May 22, 2017  
Kittitas County Community Development Services  
411 N. Ruby St, Suite 2  
Ellensburg, WA 98926  
RE: Rezone PD-16-00001

N 54°53'30" E
19.52'
SW CORNER
N 1/2 SW 1/4
PER BK 30
OF SURVEYS,
PG 12

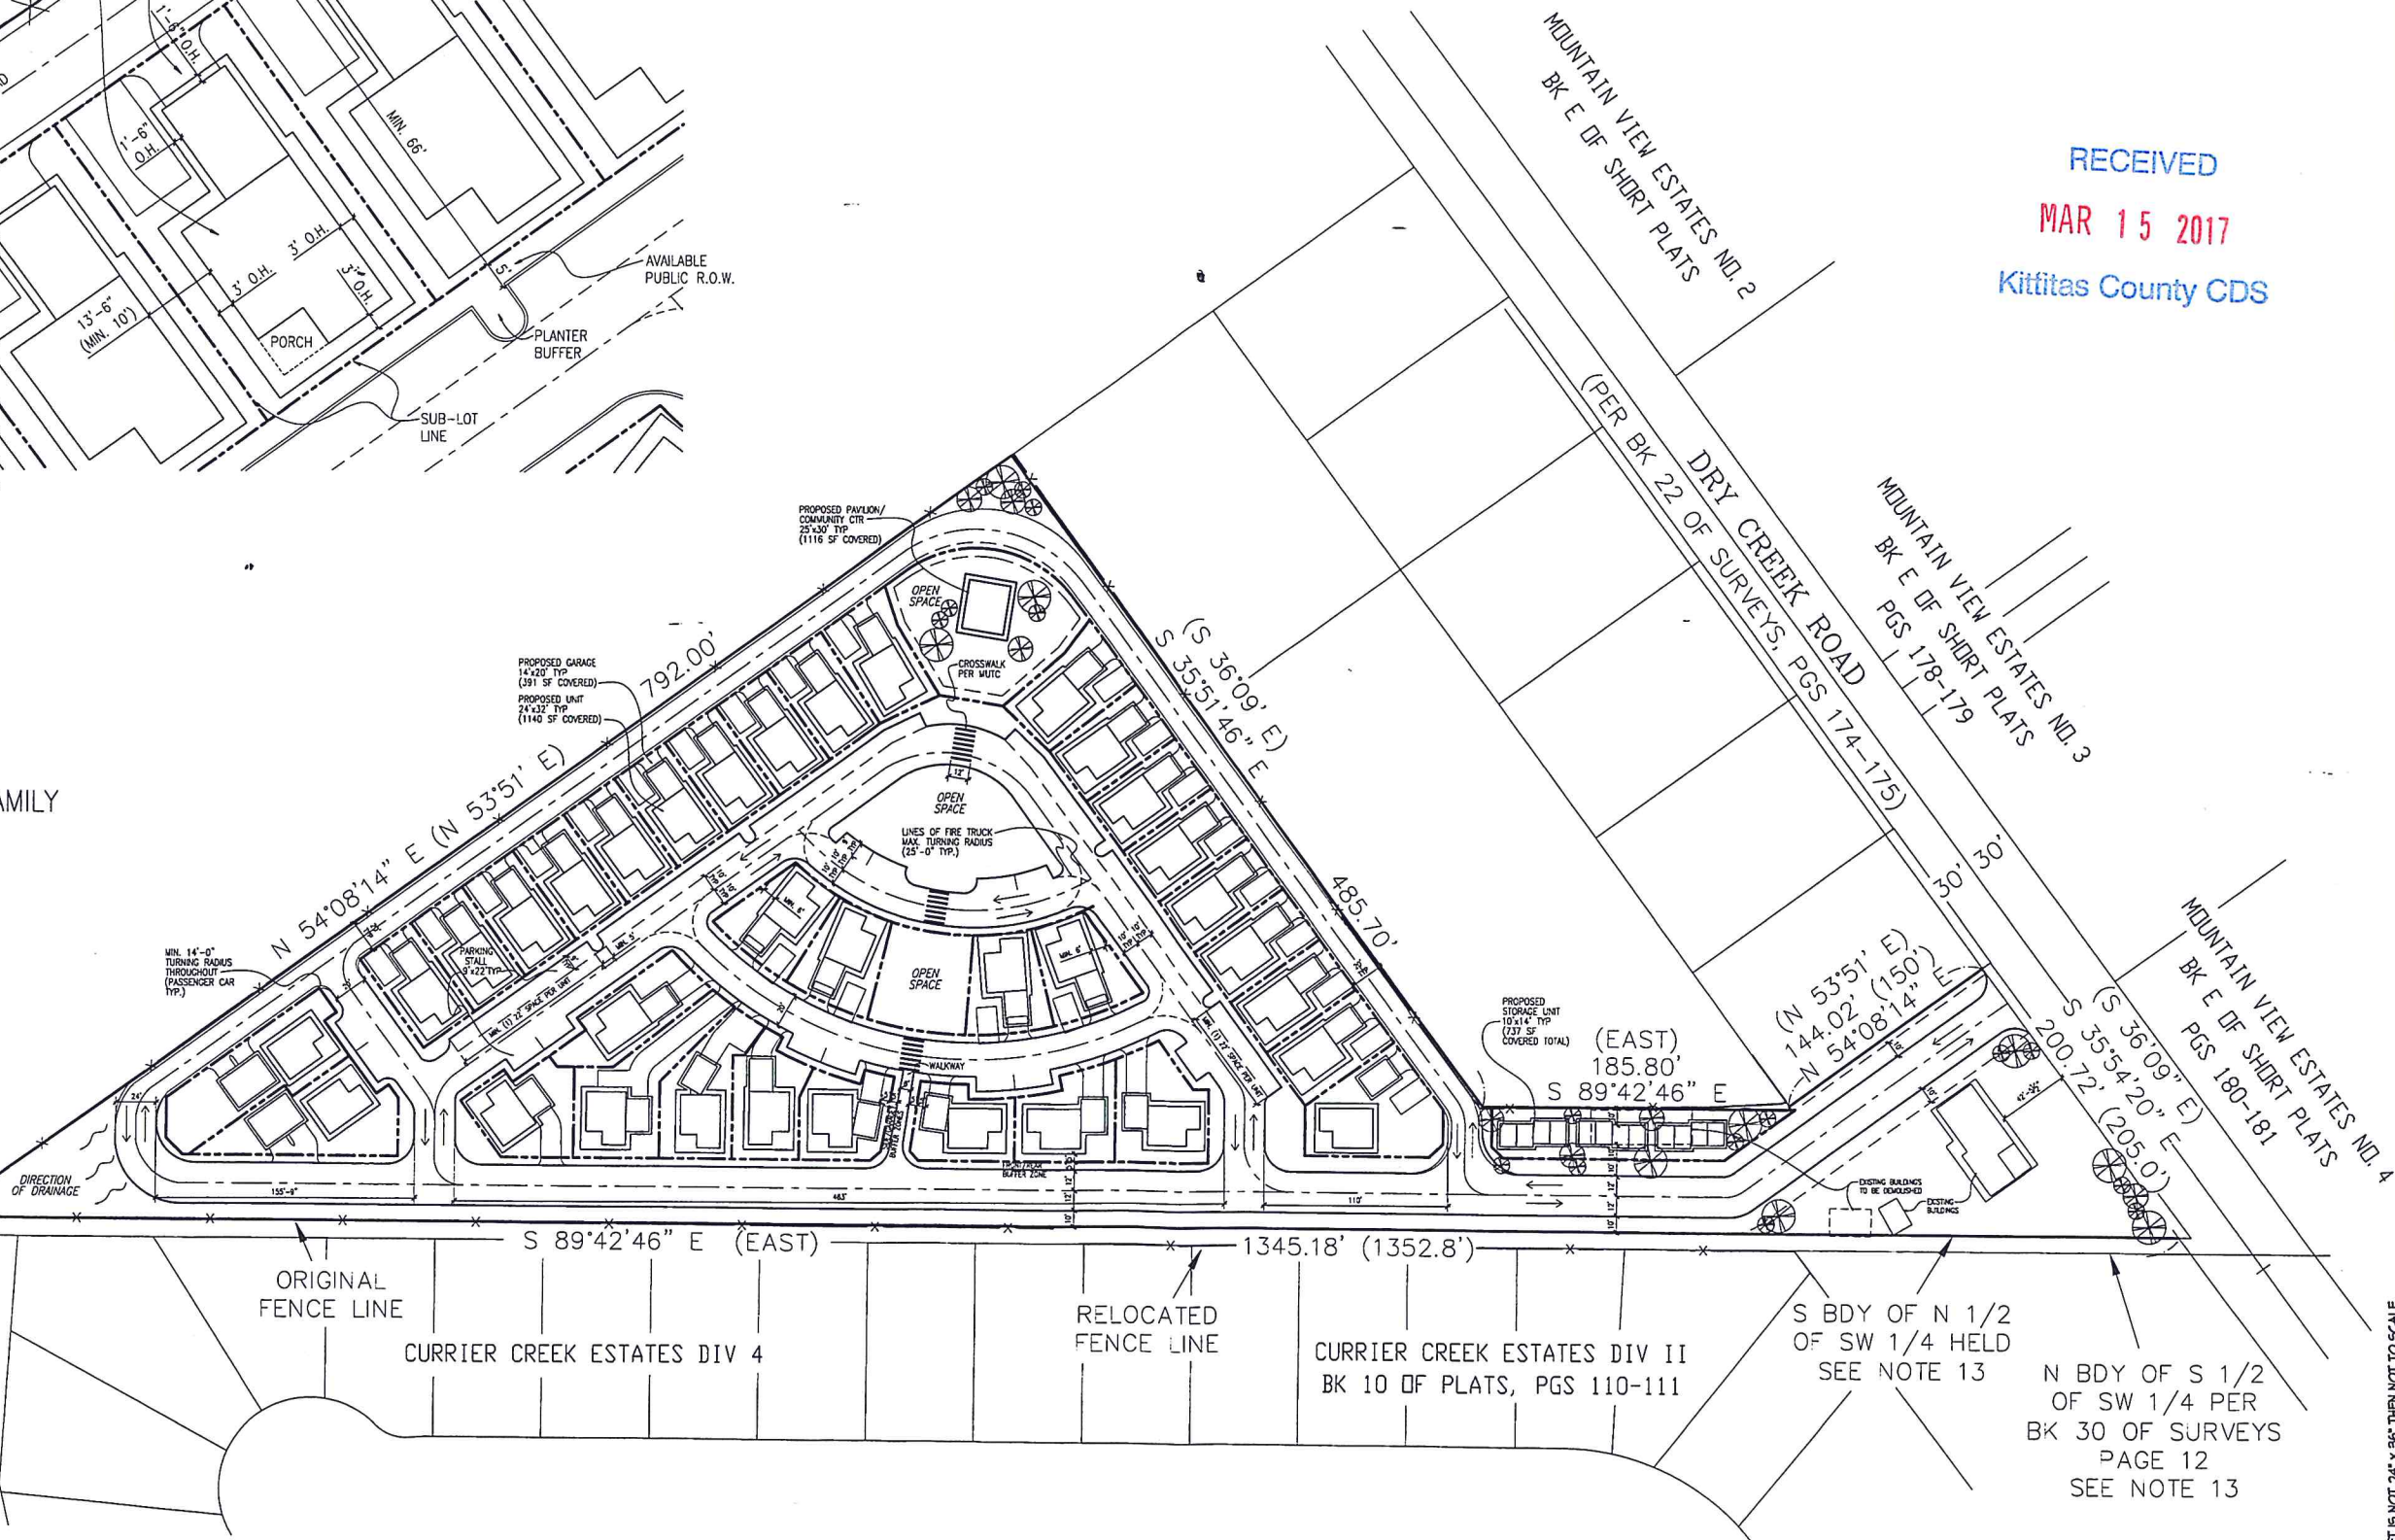
1. A corner of the property touches on Currier Creek, a creek that has seen flooding in the past two years. We are learning the hard way that simply turning empty land into high density housing in this part of the valley can create water problems and a study of how high density housing will affect water runoff here simply must be done before this re-zone is approved.

2. The parcel seems to be land locked, with no access road. It is impossible to intelligently anticipate how this development might affect traffic without some idea of how people will come and go.

3. I could find no plan for division of the property into parcels, so it is impossible to gauge the ultimate density of the development or the effects of such housing on low density neighbors. Certainly some plan for housing parcels must be presented to make an intelligent decision. There will certainly need to be some set-backs for the surrounding low density homes.
